# **OXFORDSHIRE COUNTY COUNCIL'S RESPONSE TO CONSULTATION ON THE FOLLOWING DEVELOPMENT PROPOSAL**

**Application no:** 14/01841/REM-2

**Proposal:** Reserved Matters to Outline Application 05/01337/OUT - Proposed commercial units for B1 use adjacent to the Oxford Road, including associated parking spaces and relocation of electricity substation building

**Location:** West of College House Farm, Longford Park Rd, Bodicote

Drw. no 1419 | 600 | Rev L

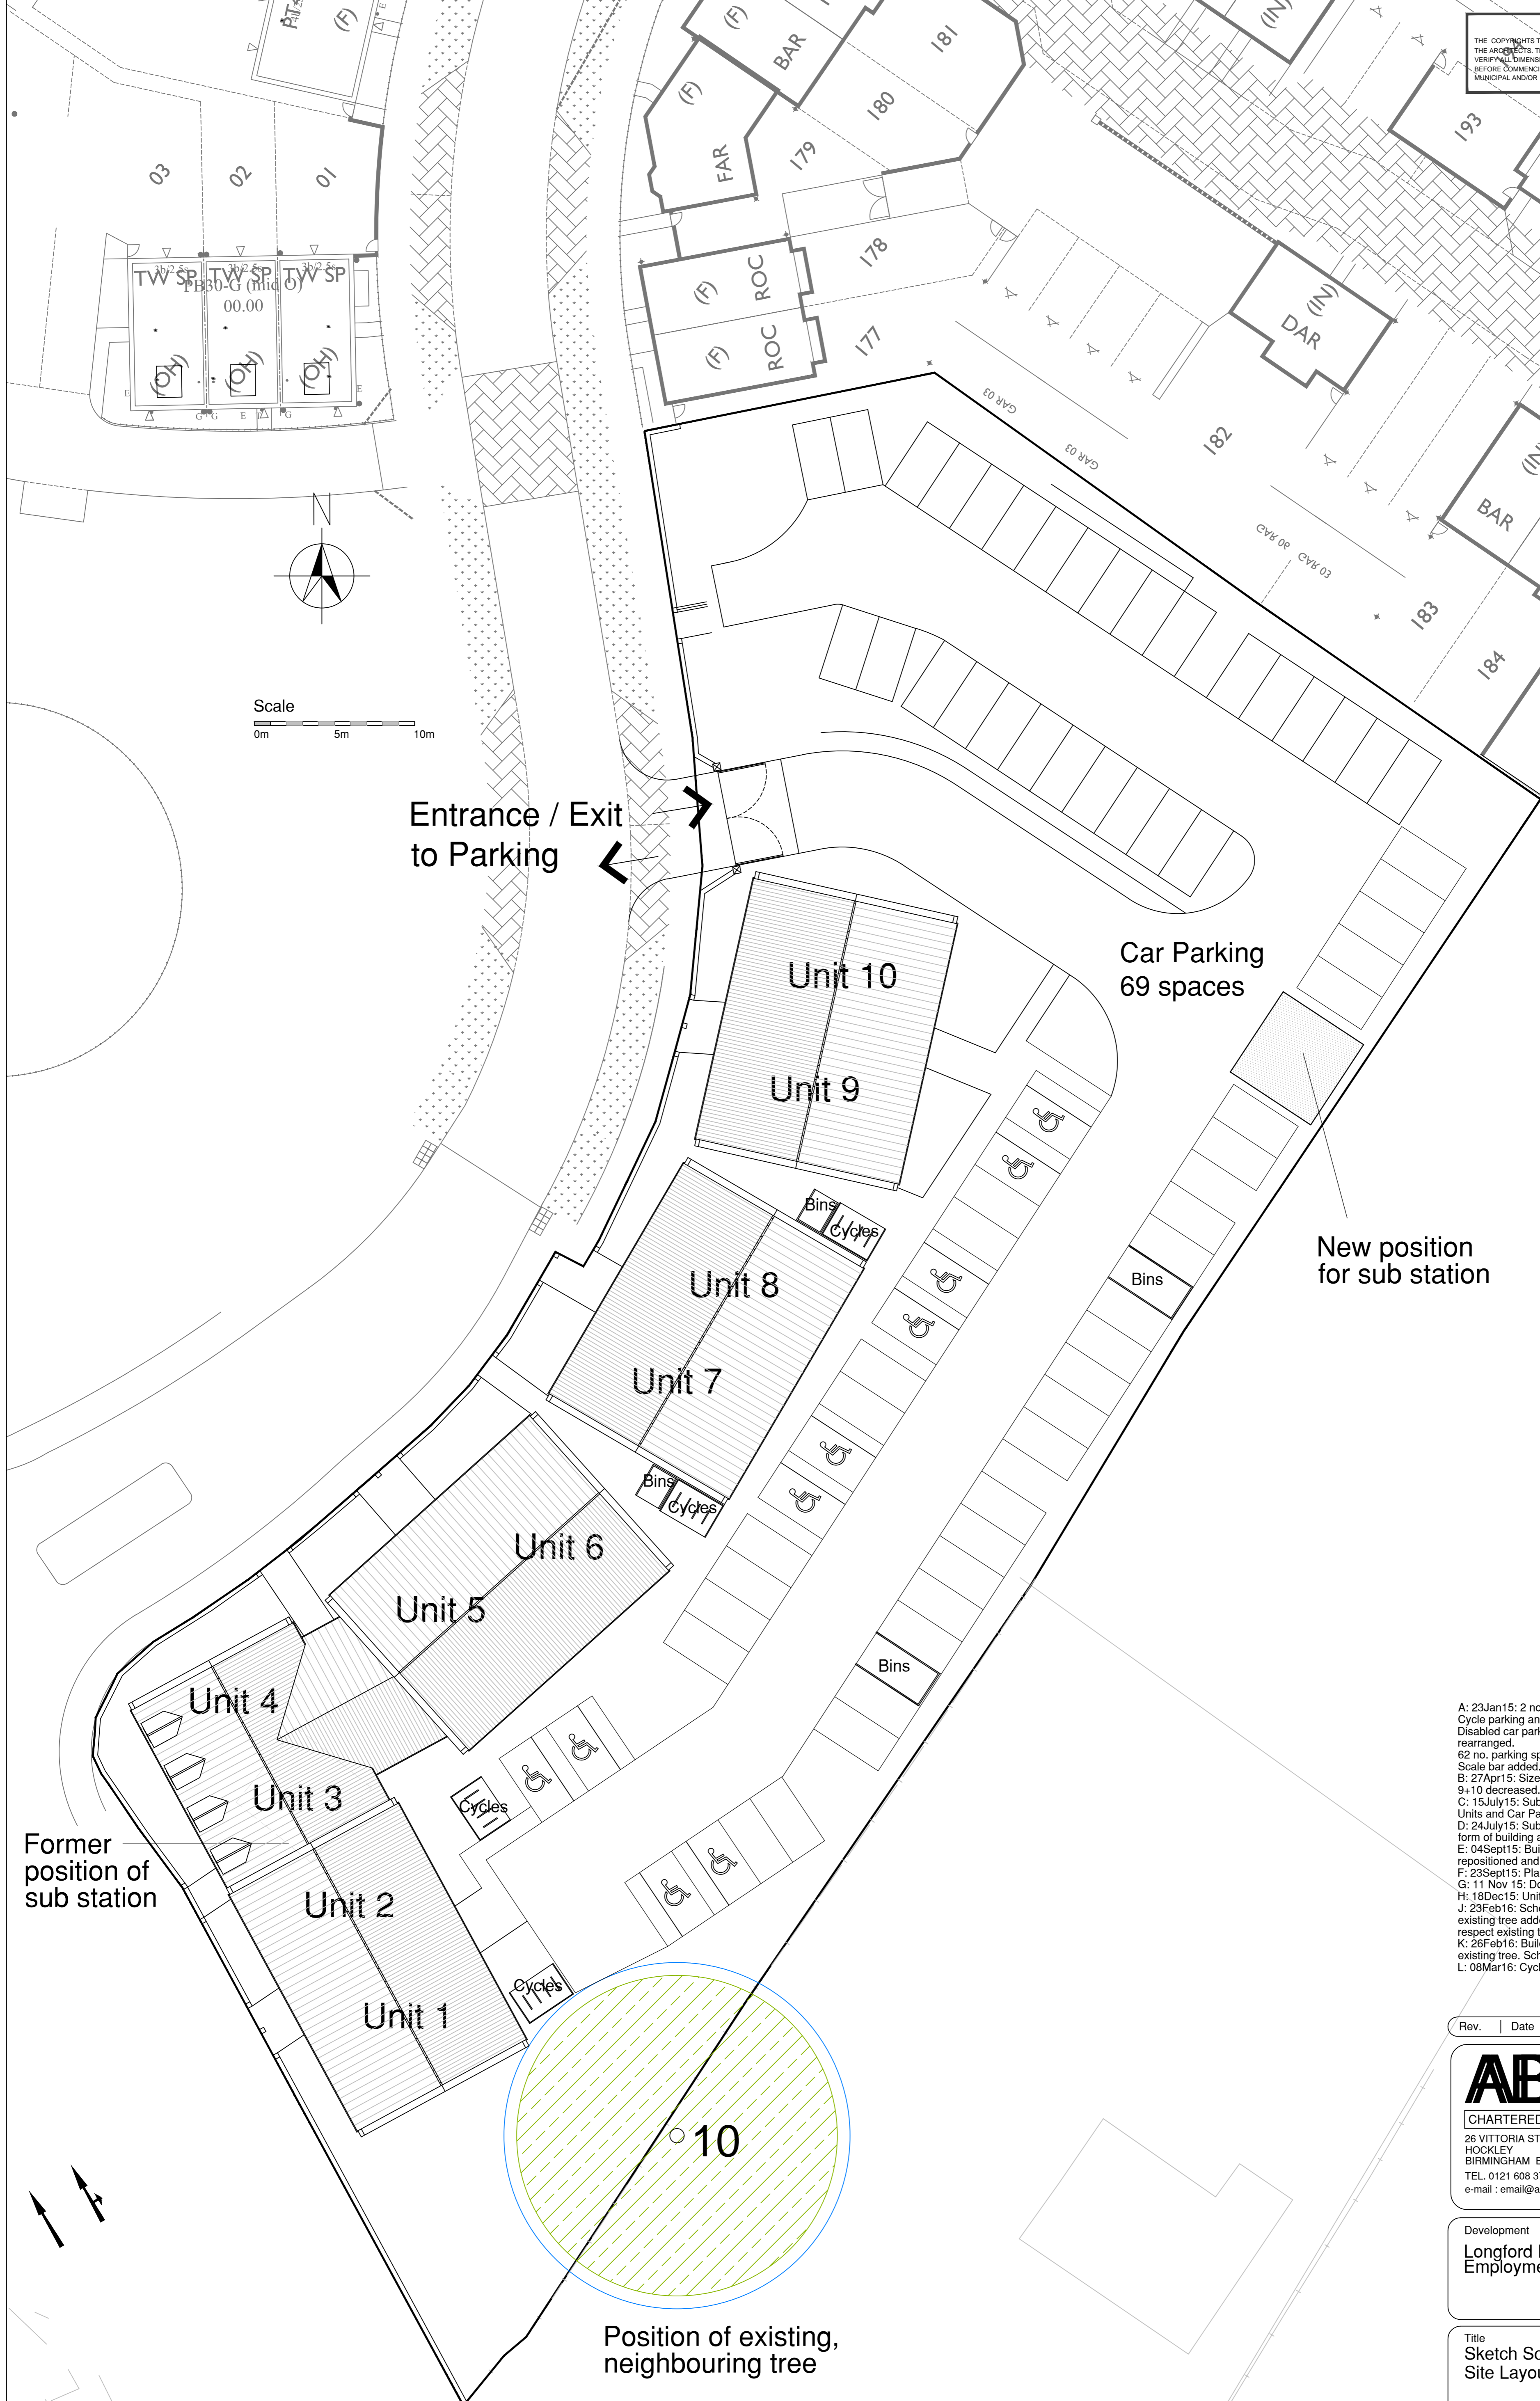
The applicant needs to provide plans that show arrangements for waste collection. It is not clear how much bin space has been allocated to each unit or building or whether all units must place their refuse and recyclable goods in the bins provided alongside the car parking spaces on the eastern side of the site for collection. If this is not the case, how will a refuse lorry access the bin storage areas located to the north and south of units 7 and 8?

Oxfordshire County Council's Residential Road Design Guide recommends that perpendicular parking spaces like the ones provided on drawing No. 1419-600-L should be 5m in length and 2.5m in width. Perpendicular parking spaces for disabled motorists should be 5.5m in length and 2.9m in width. Drawing No. 1419-600-L appears to show that the standard perpendicular parking spaces have a length of 4.8m and a width of 2.4m. Whilst these dimensions can accommodate standard sized vehicles, some large cars and vans have a length of 5m. The spaces for disabled motorists appear to have a length of 4.8m and a width of 2.5m. For more information on the council's parking standards, please see the design guide in the following link below the paragraph titled "How we do what we do":
